Extension to existing caravan park to provide 12no. additional mobile homes, associated parking area, formation of access and construction of electrical intake housing -
Amendment to application BE/42/10

Land South of Shripney Garden Caravan Park, Shripney Lane Bognor Regis

Application BE/151/11 – amended indication of layout and gates

SHRIPNEY GARDEN CARAVAN PARK, SHRIPNEY LANE, SHRIPNEY
Proposals 01 B
Nov 2011

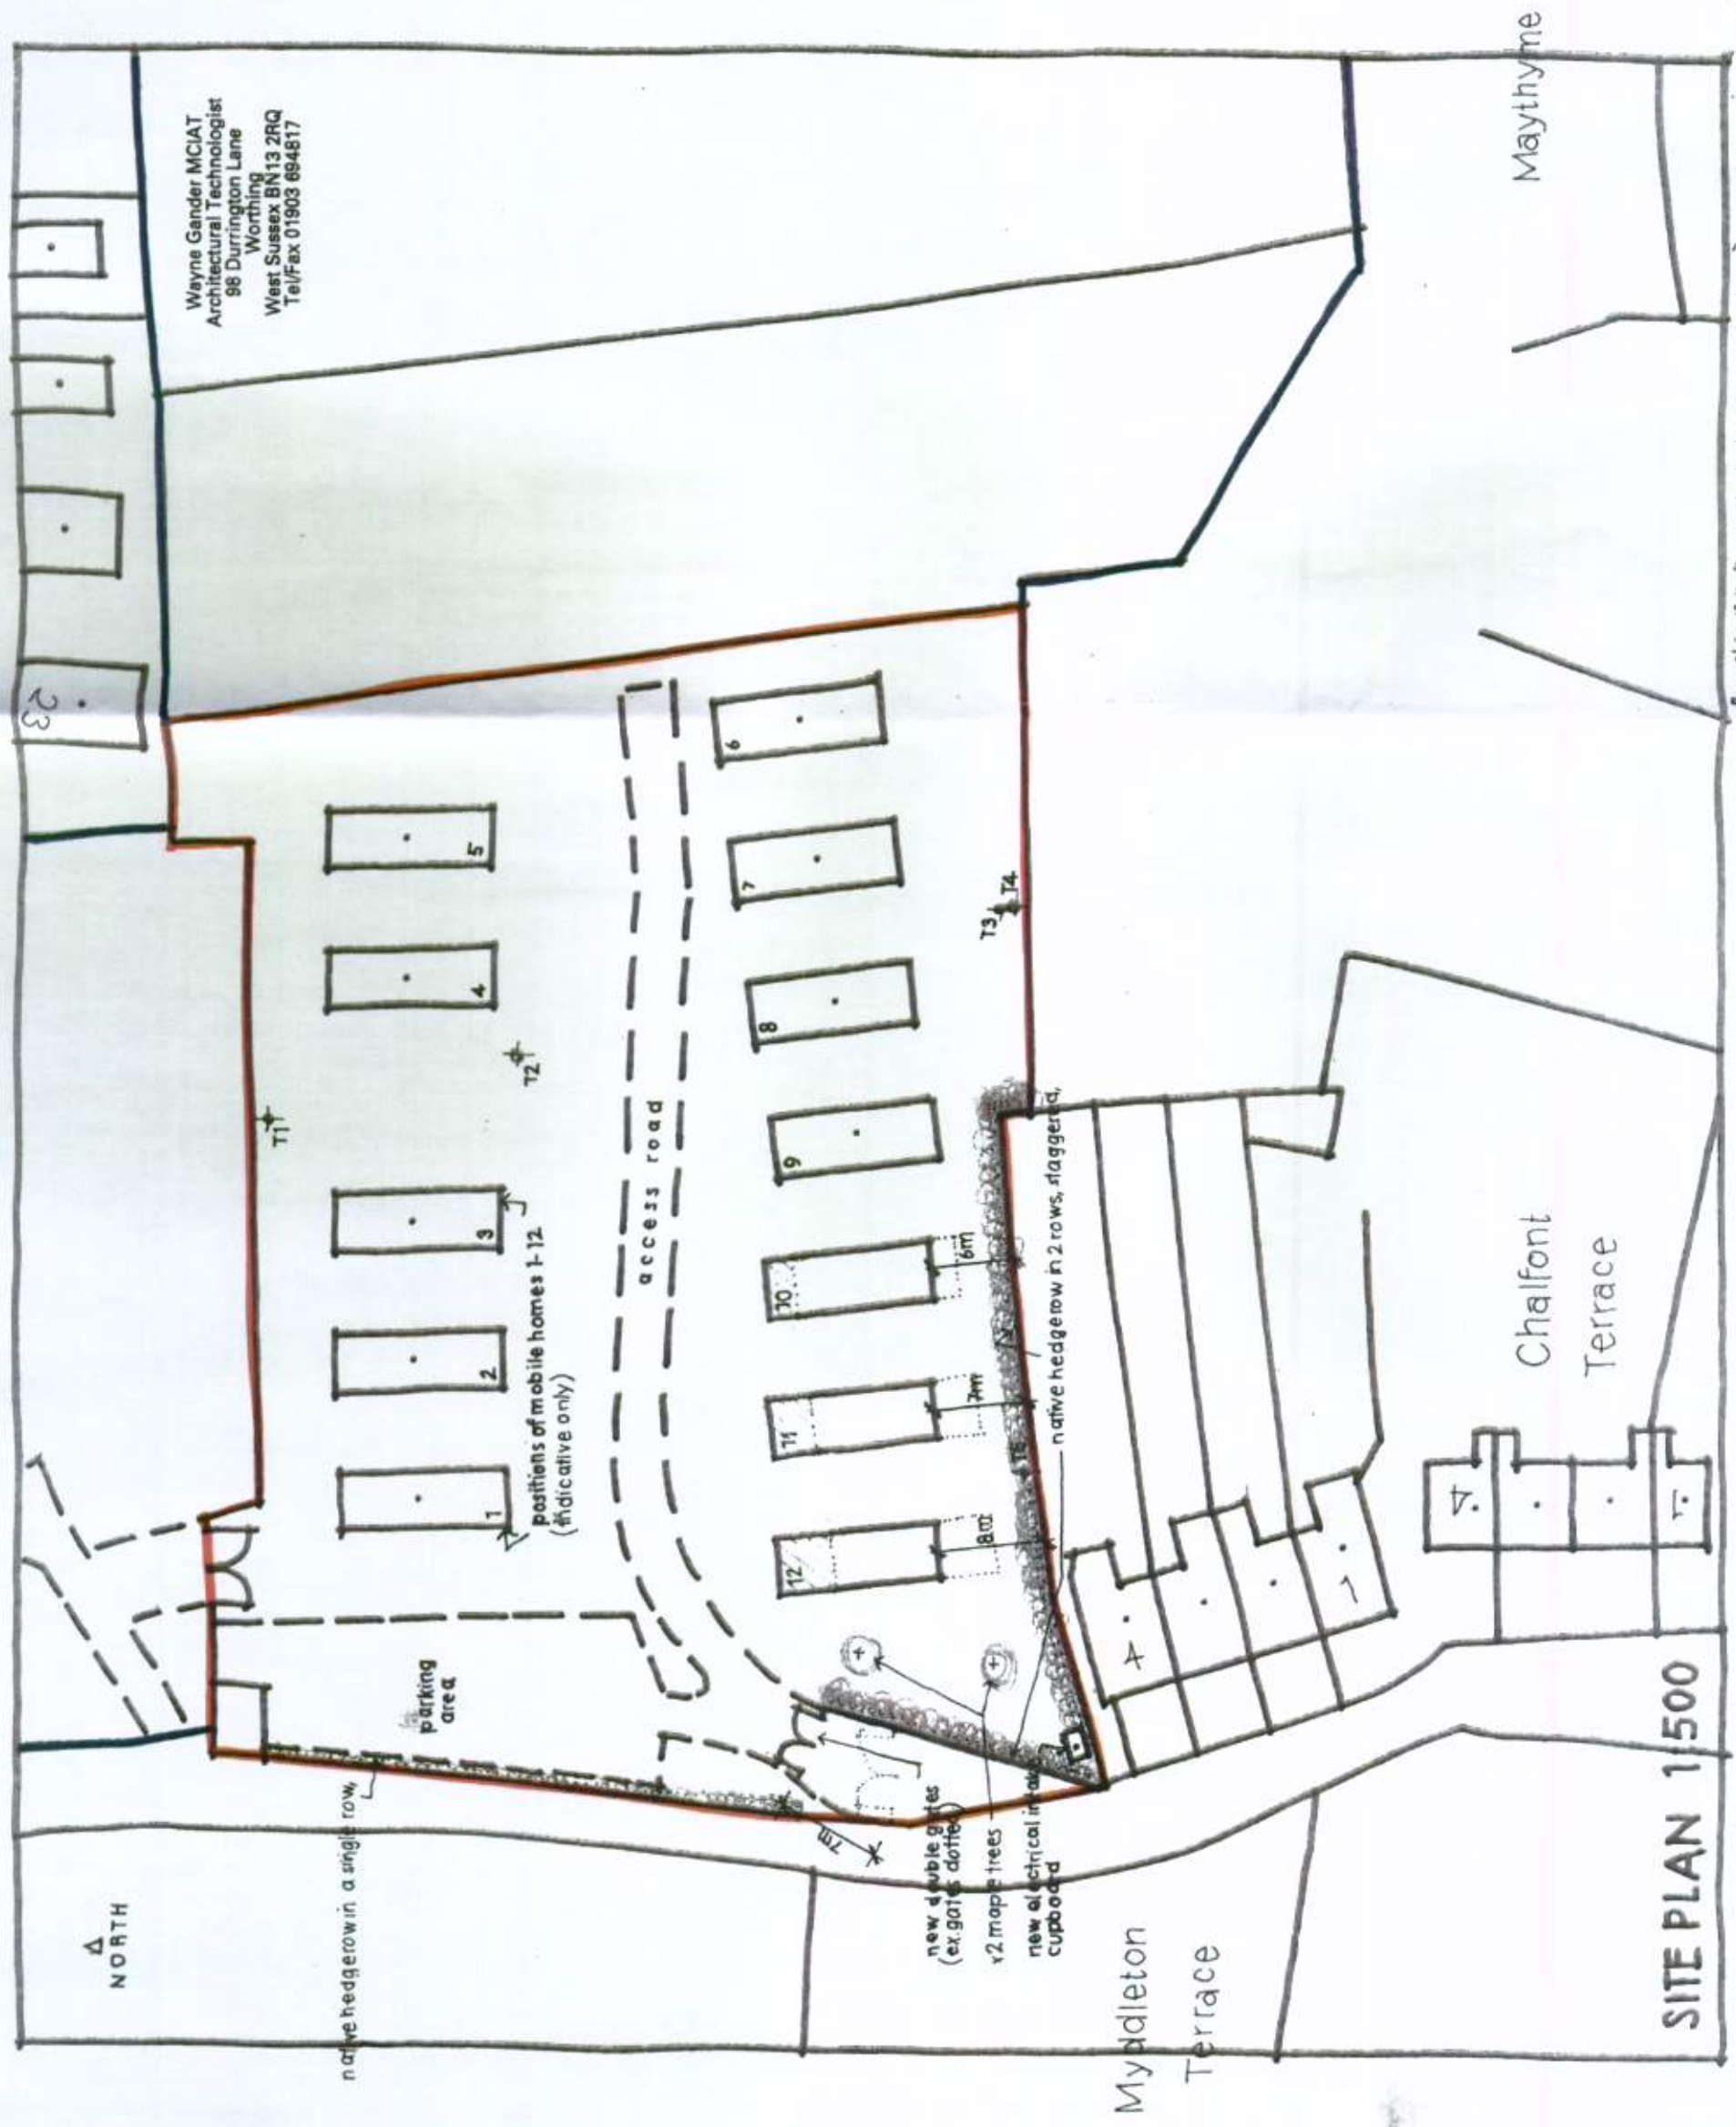
2. The new vehicular access proposed does not provide the required visibility splays to the north. The access gates have been moved back, however the access continues to adjoin the conservation area to the south and is adjacent to neighbouring property. The design is inappropriate. The access should not encroach on the conservation area and therefore there should be around 4 metres separating the conservation area from this unsightly development. There would still be plenty of room for an access to be developed that allowed lorries to turn into the site – however please note that the parish council has previously advised that the road is unsuitable for additional traffic.

3. The new layout of the concrete and concrete pads closest to the conservation area is better but I still object to their location.

- a) the pads are still too close to the conservation area – one is still less than 4m from the conservation area.
- b) there has been no attempt to address the encroachment of the extra caravan pad (and a half) to the east of the site. This is outside of the original application area and should be the subject of enforcement action to ensure the removal of at least the most easterly pad.

- c) the new plans entirely omit the extension of the access road some 30m to the east - outside of the original application area. Despite highlighting this fact previously the developer and his agents have still not entered this development on the site plans. It is clear they wish to deceive the council and decision-makers. The road was not on the original plans, is outside of the original area given planning permission, it is unsightly, takes more prime grade agricultural land out of circulation and should be removed immediately.

4. The original plans proposed native hedging to the south of the plot around (and to the east of) trees T3 and T4. There is little screening in this area and therefore the original plan should be followed and the border planted with a double row of mixed native species (rather than the conifers currently planted).

5. There is no indication on the revised plans that the electricity sub-station will be moved – and therefore (for reasons described in my previous letter), since it abuts an adjoining property and the conservation area, the application should be rejected.
